CITY OF ALBUQUERQUE

August 10, 2009

Re: IHOP Restaurant, 10605 Central Ave NE Grading Plan
Engineer's Stamp date 8-4-09 (L21/D040)

IHOP PRIVATE AREA DRAIN
NTS

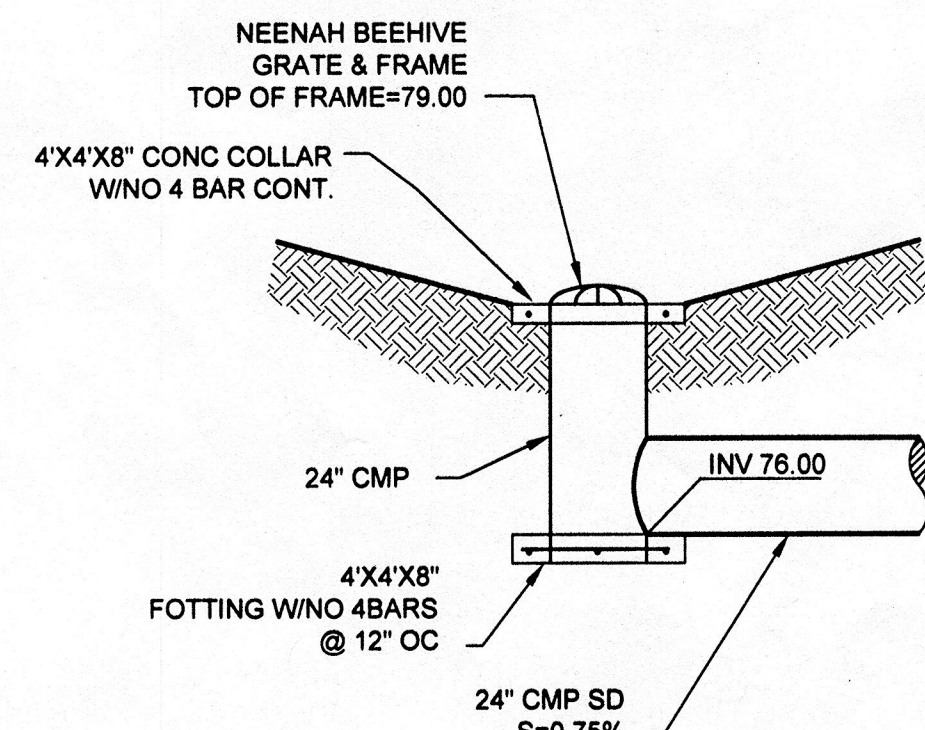
The build note to connect the 4 inch roof drain off the southwest corner of the building to the 24 inch storm drain was inadvertently dropped in this revision. Include this in your Certification when submitting for Certificate of Occupancy.
